**STATE SIGNIFICANT DEVELOPMENT 9827 – HORIZON AT LEE 5, MIXED-USE DEVELOPMENT, 45 HONEYSUCKLE DRIVE, NEWCASTLE**

The Hunter Regional Committee of the National Trust has reviewed the *Heritage Assessment* (Umwelt, May 2019) for the proposed mixed-use, 8-storey State Significant Development [SSD-9827] at 45 Honeysuckle Drive.

Figure 18 - Extract from the NSW Planning Portal Heritage Layer.

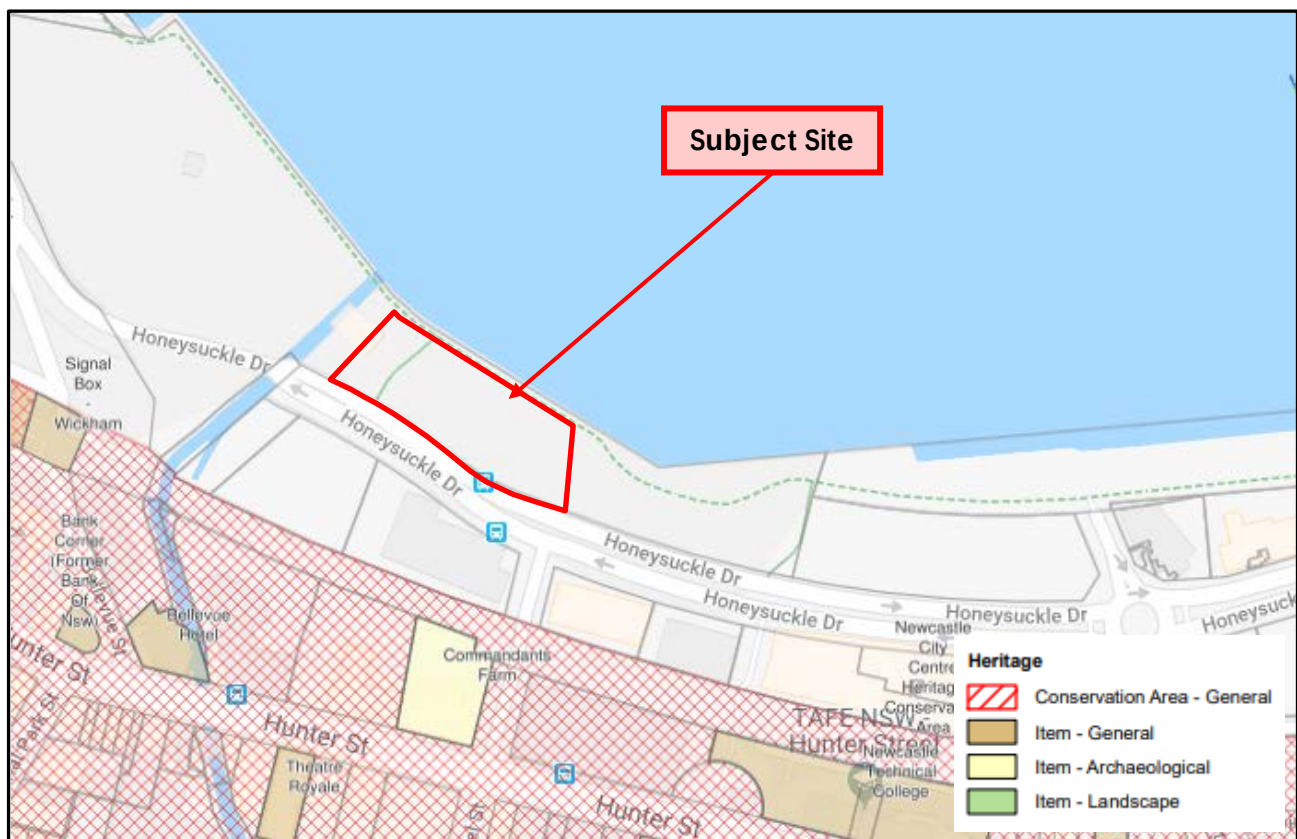
Table 3.2 identifies several non-aboriginal heritage-listed items **within 400m** of the Lee 5 project area. The National Trust is disappointed that this table fails to identify the **Wickham School of Arts** and its contributory companion buildings – a 19<sup>th</sup> century terrace and the inter-war Mullens Cordial Company office and residence, abutting the School of Arts.

The Wickham School of Arts, 80 Honeysuckle Drive, Lot 1, DP 1009228 is listed in NLEP 2012, Schedule 5 as **heritage item 1690**. In our estimates, the School of Arts lies 190m westward of the south-west corner of the project area. Seemingly, almost every map and image in the *Heritage Assessment* is cropped to exclude the western visual curtilage of the project area. This is possibly because Umwelt have confined their assessment to the defined 'Honeysuckle' precinct which they state is bounded in the west by Cottage Creek. We note that the **EIS** includes a map which shows a straightened Honeysuckle Drive passing directly through the School of Arts site – indicating an earlier intent to demolish this listed heritage item.

Unlike other heritage-listed items identified at Table 3.2, the School of Arts is not screened by recent Honeysuckle developments. Our concern is for the preservation of context – the setting and sightlines to and from the harbour. The School of Arts was erected on the natural, pre-reclamation Hunter River foreshore at the mouth of Cottage Creek and performs an interpretive function in this regard.
